Response to Planning Application

Application ref: P/38/21/PL

Description: Extension to existing agricultural barn. This site may affect the setting of a listed building & is in CIL Zone 5 (Zero Rated) as other development

Location: Little Sefter Farm Pagham Road Pagham

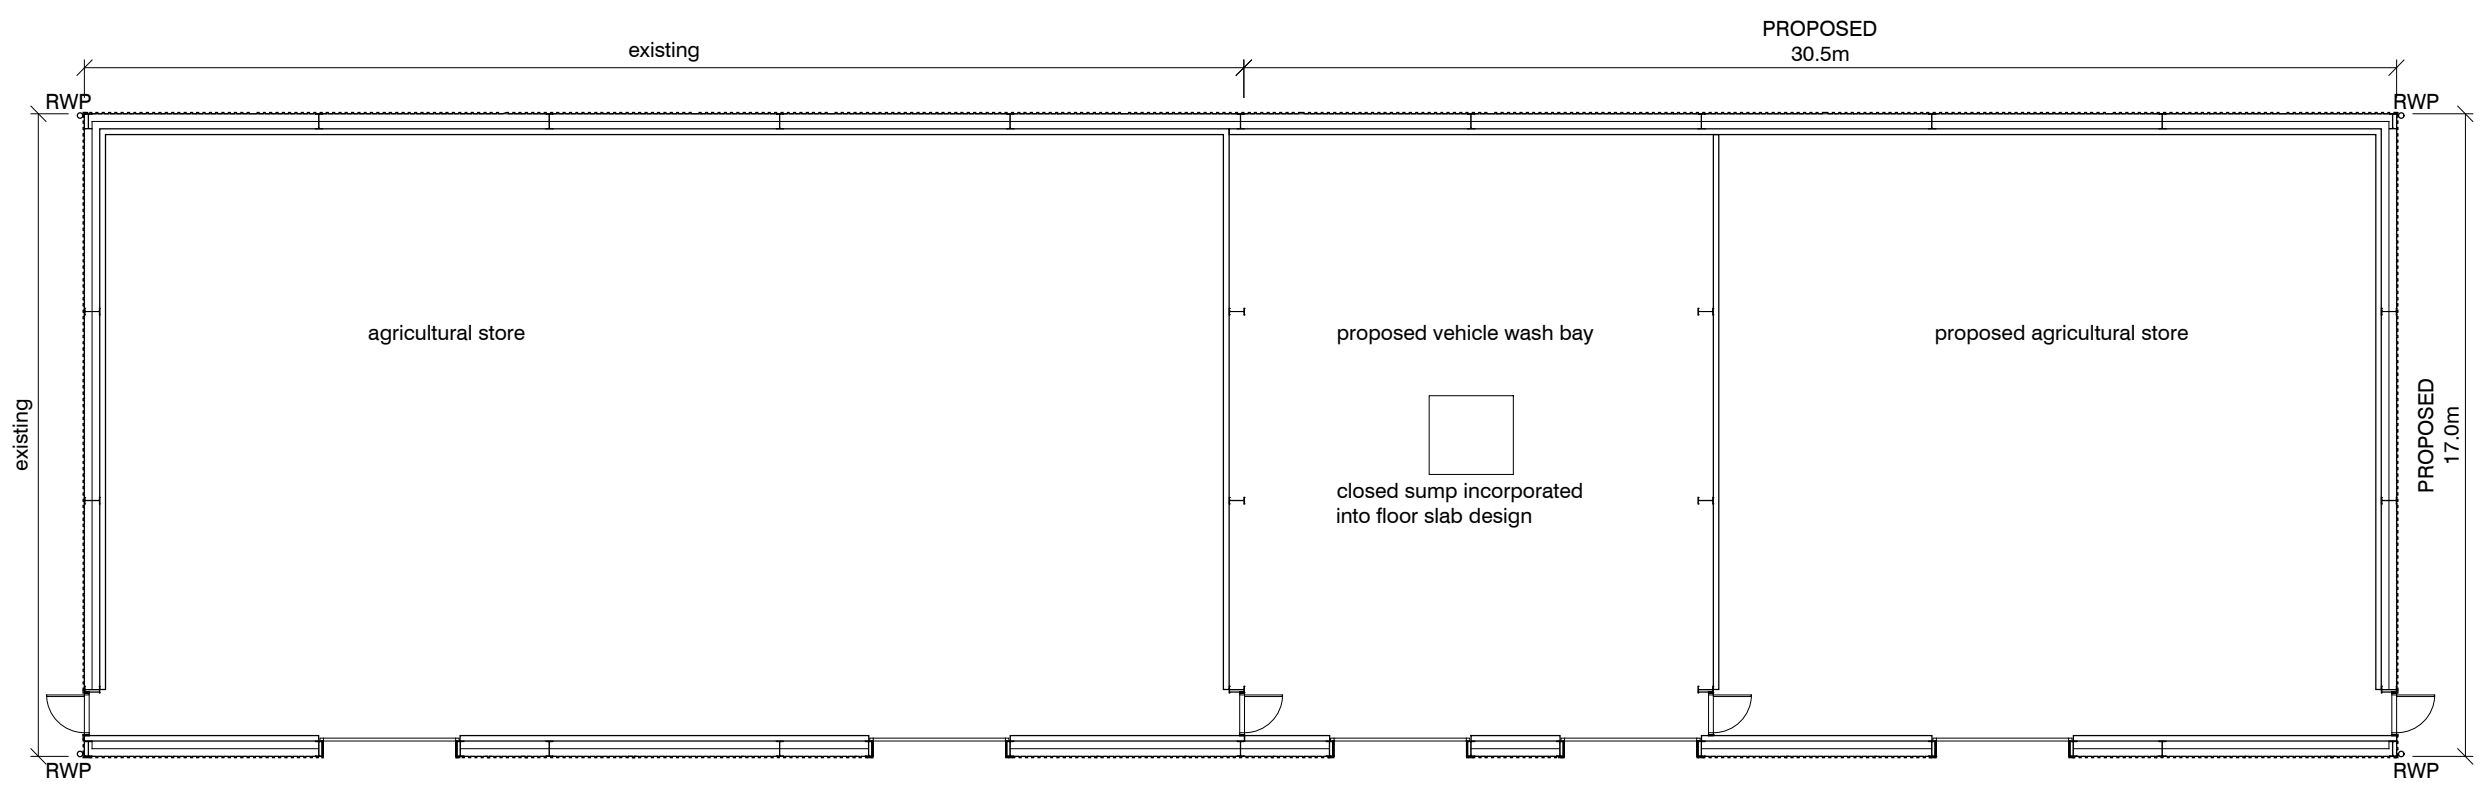
These proposals are for extension to existing, however the extension is at a scale that it would be visible from the road and surrounds and will require landscape mitigation to be implemented.

The existing and proposed site block plan and floor plan and elevations 002 Rev 04 dwg has shown indicative planting however this has not been shown in detail which would need to be submitted in plan form to clearly show planting species, actual quantities, planting densities and size at time of planting. The

mitigation planting will need to act as a buffer to both the exiting and proposed extension and help to screen from the road. The proposed planting would need to be at a size that provides instant impact and has immediate mitigating effect.

Advise landscape screening mitigation required for these proposals to be submitted in plan form with specific detail as above.
